BR/198/19/NMA

## Application for a non-material amendment following a grant of planning permission: Town and Country Planning Act 1990

NEW ROOF WITH FIRST FLOOR ACCOMMODATION, DORMER TO SIDE ELEVATION,  
PORCH TO SIDE ELEVATION & SINGLE STOREY REAR EXTENSION  
(REV. TO PREV APPROVED BR/305/17/HH)

FRONT ELEVATION

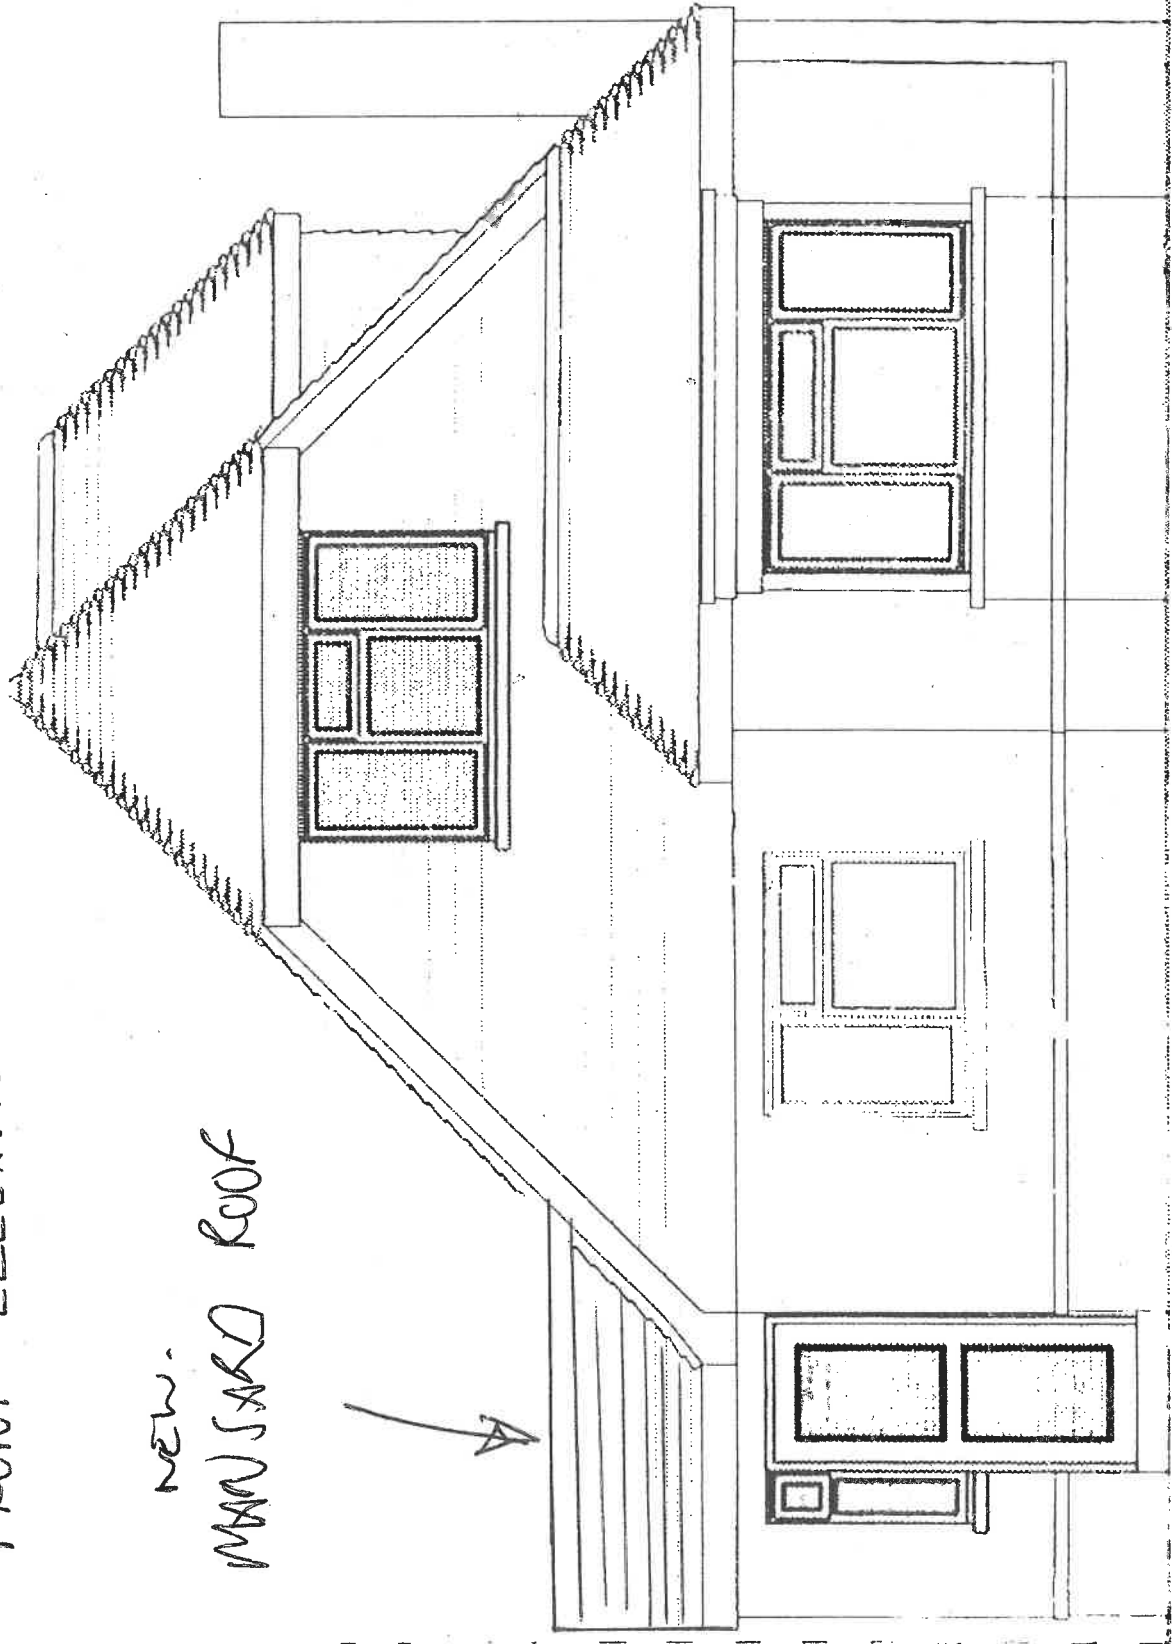
1. PROPOSED + APPROVED JULIETTE BALCONY WINDOWS TO REAR 1st FLOOR/GABLE CHANGE TO A SINGLE OPENING WINDOW, DUE TO NEIGHBOURS COMPLAINTS, ABOUT POSSIBLE USE OF EXTENSION ROOF AS BALCONY.
2. PORCH FULL PITCH ROOF CHANGE TO MANSARD + FLAT ROOF TO REDUCE SIZE + IMPOSING NATURE + ALLOW LIGHT TO NEIGHBOURING PROPERTY.
